**Consultation Response from KC,
Lead Local Flood Authority**

2025/93462 Acre Mills, School Street West, Oakes, Huddersfield, HD3 3EB

Demolition of vacant existing building 17 and erection of 2 storey industrial manufacturing unit with external landscaping, car parking, external storage, external plant and new perimeter fencing

Date Responded: 6th February 2026

Figure 5.1: Risk of Flooding from Surface Water Climate Change Extents

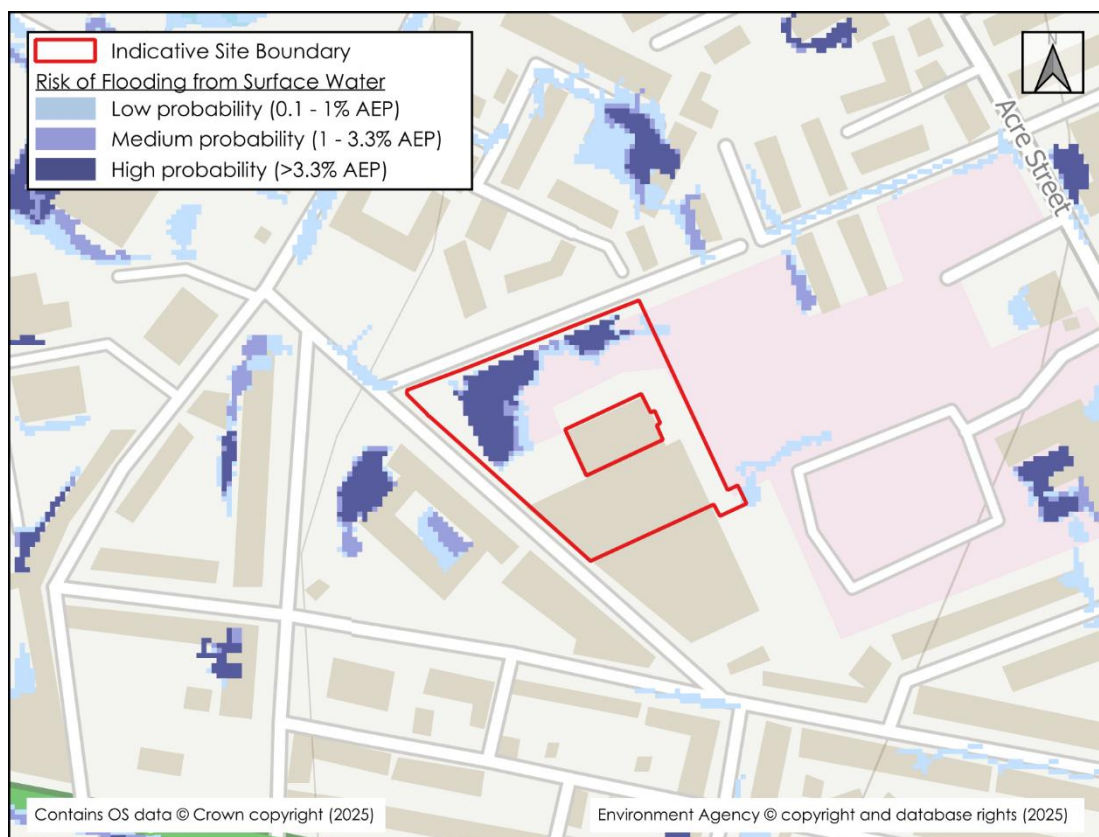
- *Areas of surface water ponding withing the wider mill site are shown on 3rd generation flood risk maps, within the red line boundary adjacent to building 18. Depths in the 1 in 100-year event are shown to be up to 900mm deep.*

Surface water flood risk has not been assessed and is simply dismissed saying 'bigger pipes will be used'. Local depressions in the topography should be studied and assessed for where new development is to be located, e.g. road and parking areas.

Appendix 1: Proposed Site Drainage Layout

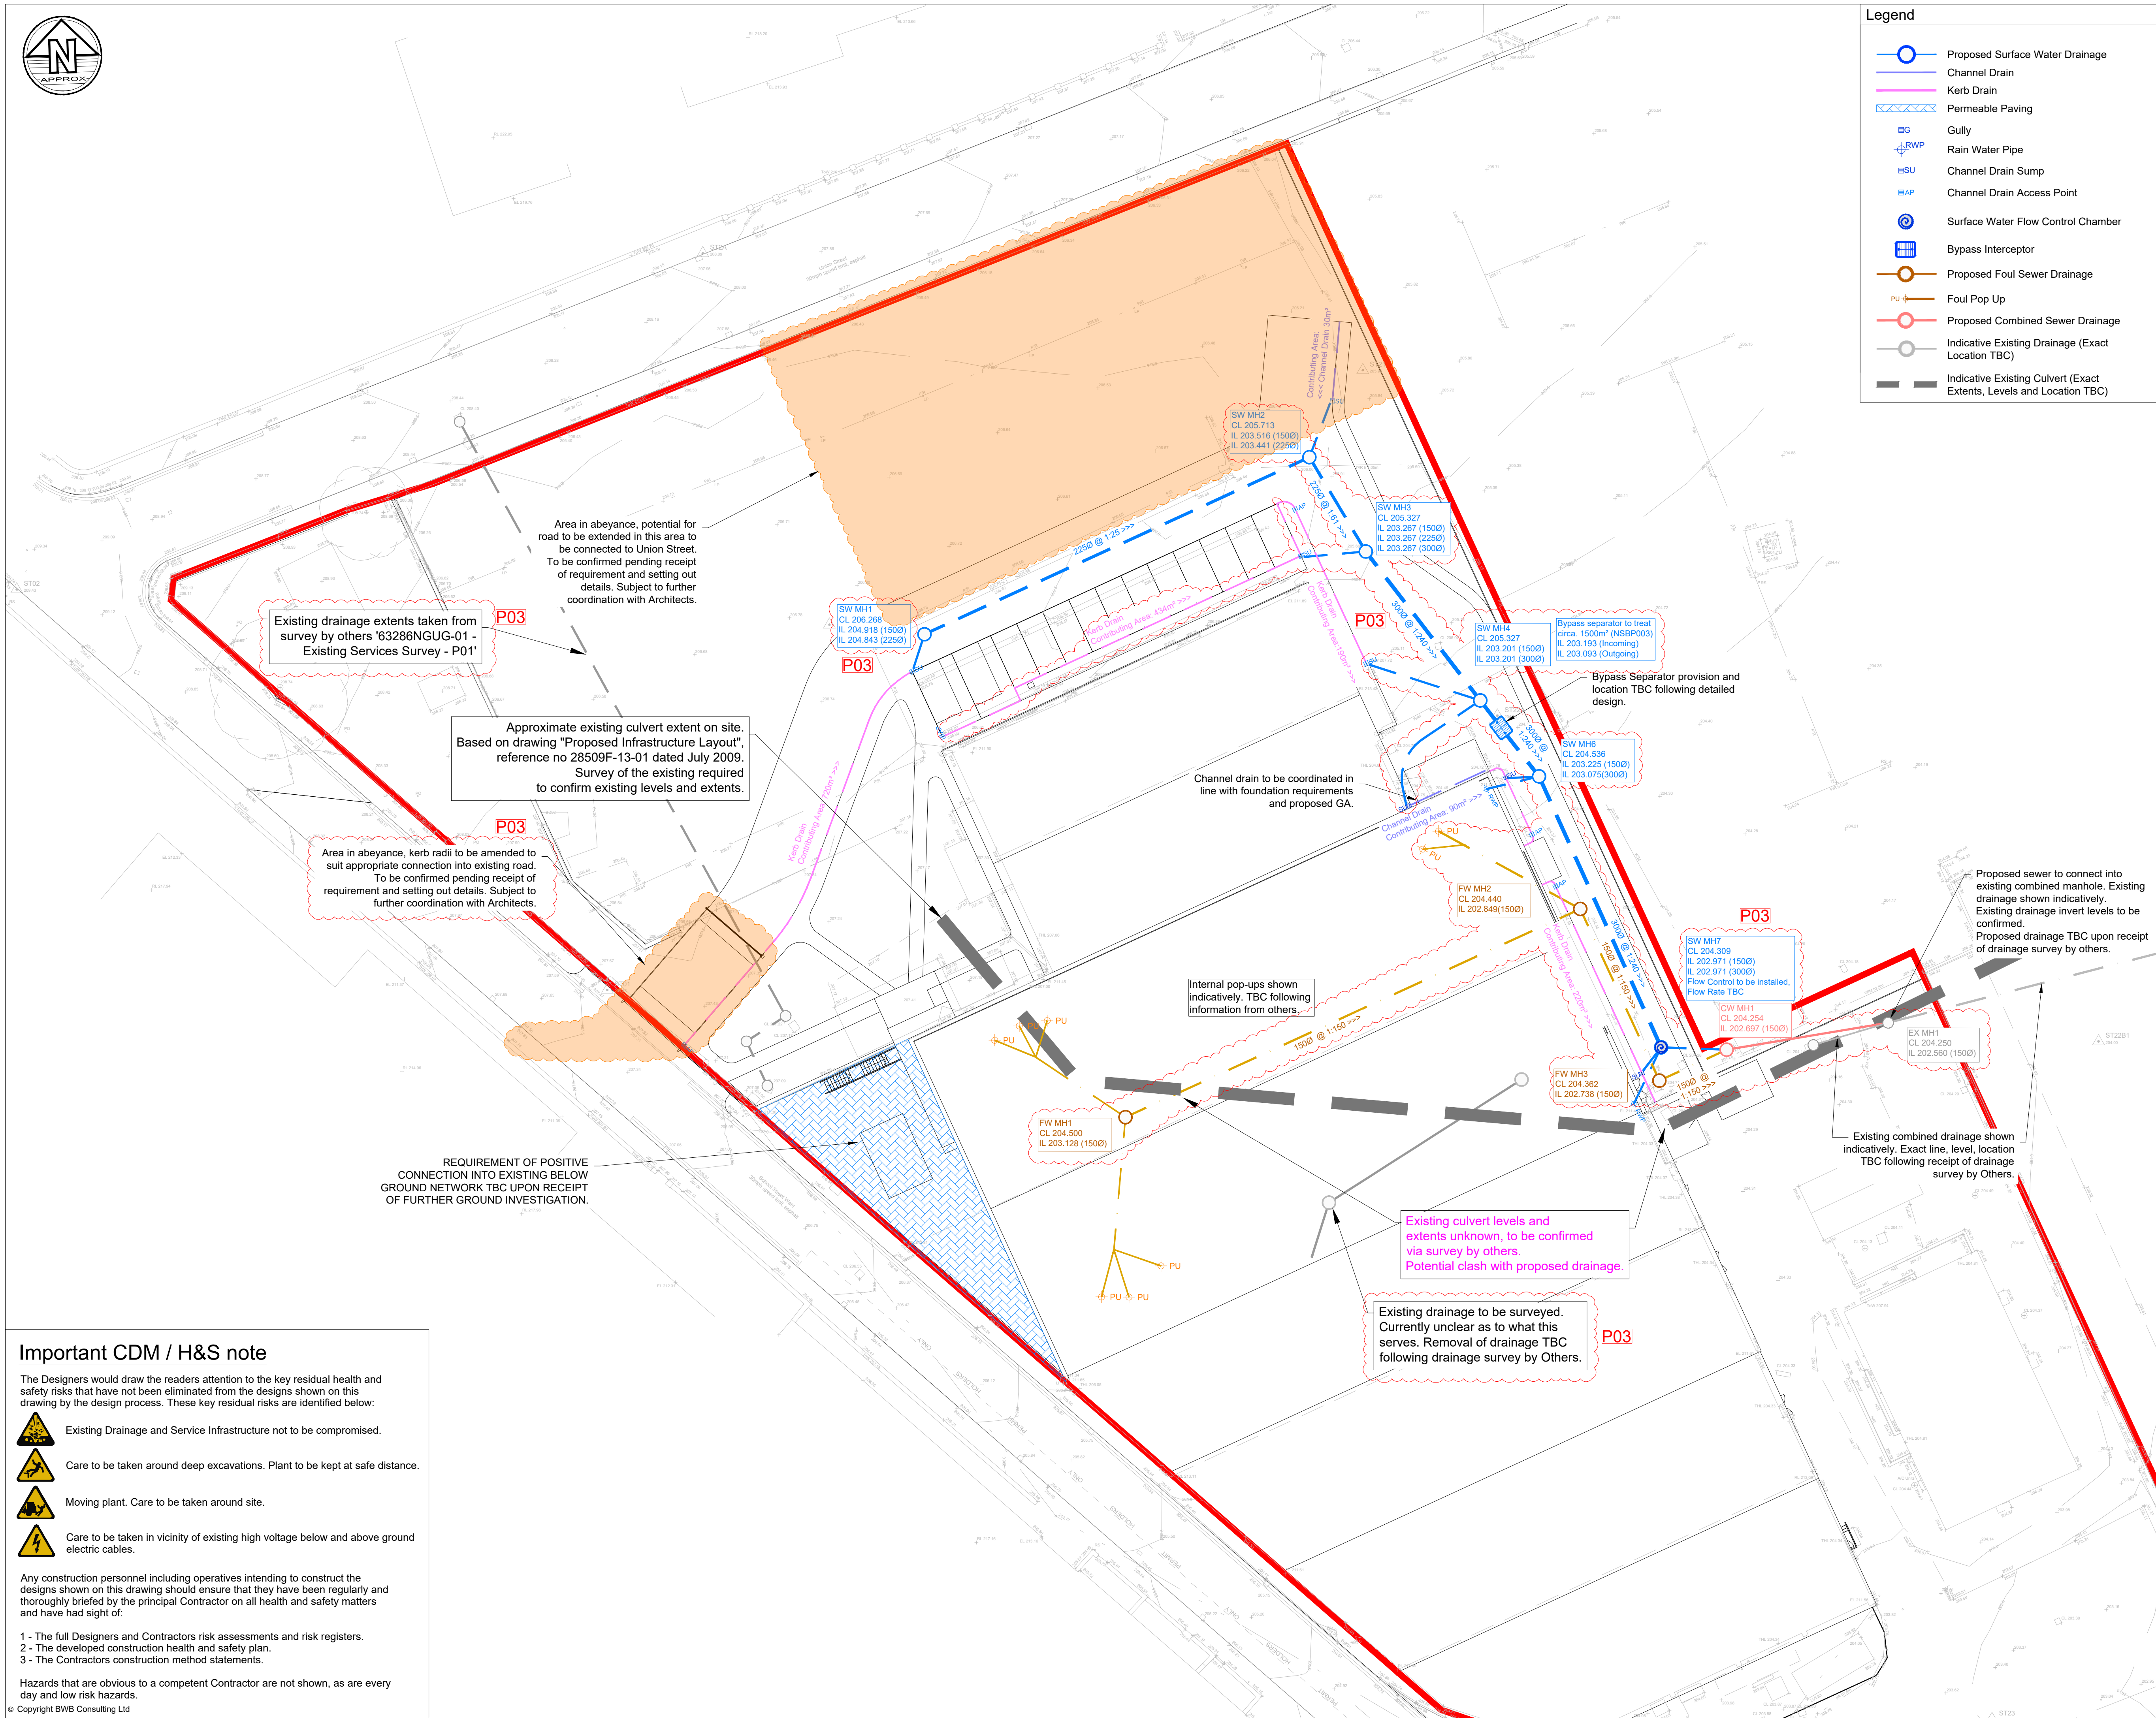
- *It appears that the footprint of buildings is not going to change. A new roof does however allow consideration of green or blue/green roof areas to slow flows into the local drainage network and a sustainable development.*

This does not mean attenuation is not going to be enforced as suggested in the submission, we have specifically suggested a new building could consider rainwater storage in the roof void if space is limited on the ground.

The site mentions that it doesn't think infiltration techniques are suitable yet proposes just that, areas of permeable parking. Localised run off from footpaths could shed to adjacent landscaped areas, also there a possibility of rain gardens from trees around parking areas and the land used for biodiversity new gain.

Drainage maps show interceptors yet there is an assumption existing drainage connects to combined sewer (i.e. will be treated at a wastewater treatment works). Several surface water pipes are described but not fully surveys.
